The petition proposes to allow for the redevelopment and expansion of the existing Panthers’ Practice Facilities and associated accessory uses.

Panthers Stadium, LLC

Staff recommends approval of this petition upon resolution of outstanding issues related to land use, site and building design, and infrastructure in addition to requested technical revisions.

SHEET TITLE
PEDESTRIAN CONNECTION
 SHEET NUMBER
RZ-5.0

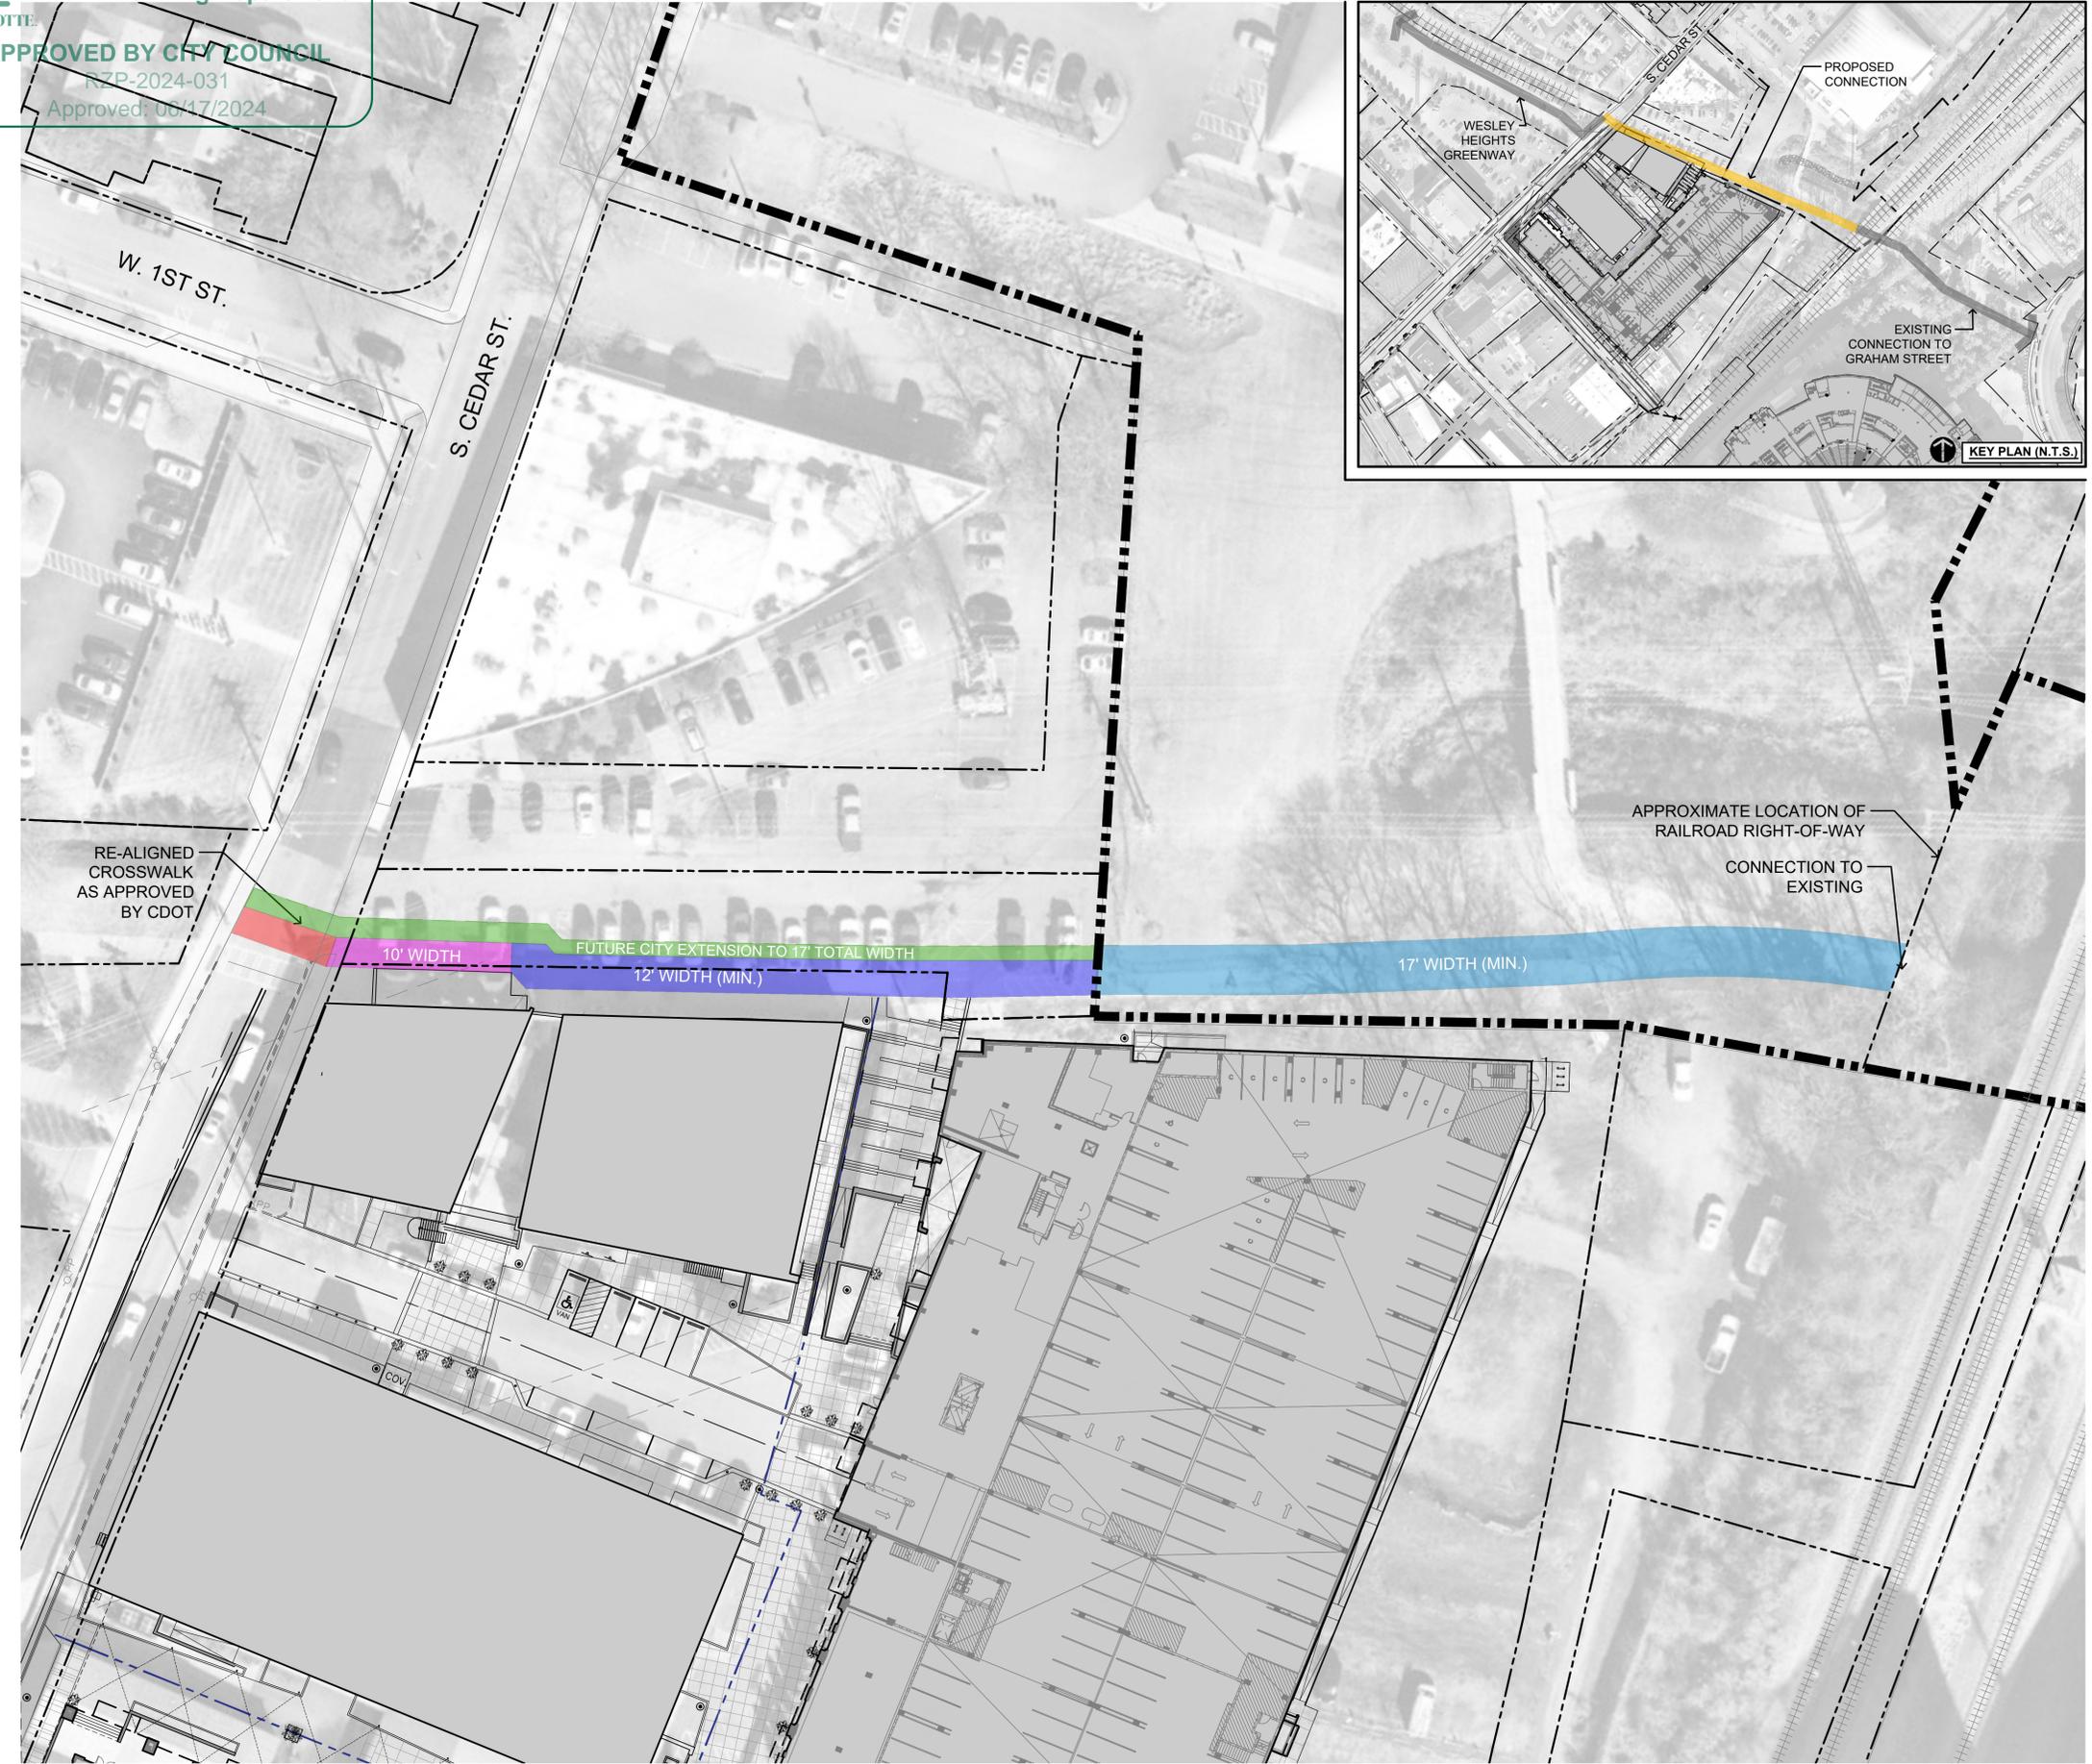
20. ~~Revise the conditional notes on the pedestrian pathway to note that what is being proposed is the reconstruction and improvement of the existing pathway to a 12' shared-use path. Add notes on any additional improvements such as lighting or signage. Indicate that public access to the path will function similarly to current operations.~~
